Harnett County Government Complex  
307 W. Cornelius Harnett Boulevard  
Lillington, NC 27546

**RE: Harnett County Land Use Application for Existing Tank # 09-5-22240**

The Harnett County Department of Public Health, Environmental Health Division on June 10, 2009, evaluated the above referenced property at the site designated on the plat/site plan that accompanied your existing tank application. According to your application requesting a proposed storage building, the evaluation was done in accordance with the laws and rules governing wastewater systems in North Carolina General Statute 18A.1950 including related statutes and Title 15A, Subchapter 18A, of the North Carolina Administrative Code, Rule.1950 and related rules.

Lot 13 Johnson Farms S/D

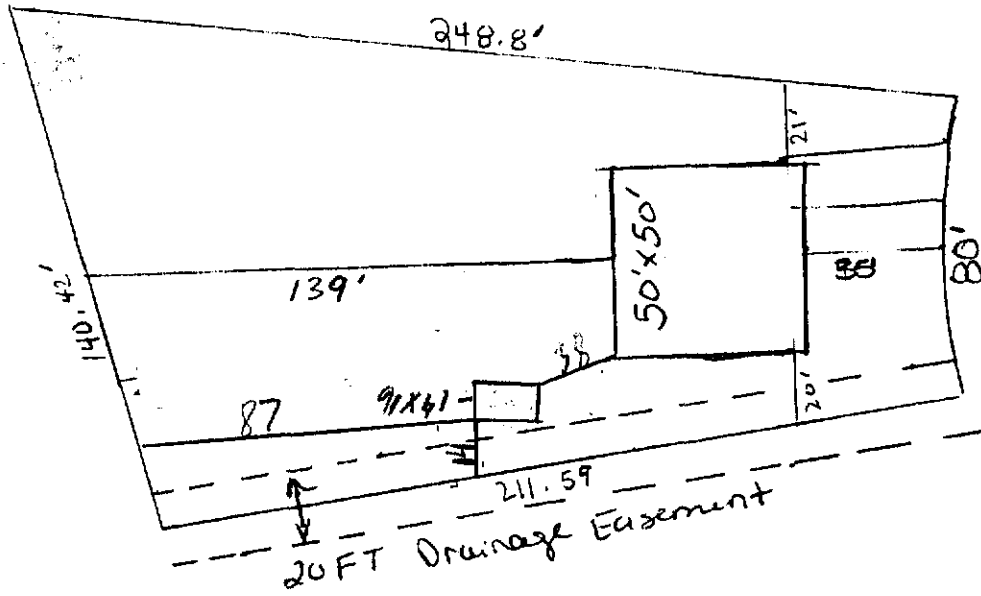
- 15A NCAC 18A.1950 a(16) Any swimming pool must be 15' from any part of septic system.**
- 15A NCAC 18.1945 (b) Each lot shall have original septic system plus repair area.**
- 15A NCAC 18A.1950 (10) – Any building to be 5' from drain line. (Your proposed building will be on the drain field. You also need to replace the handles on septic tank lid.)**
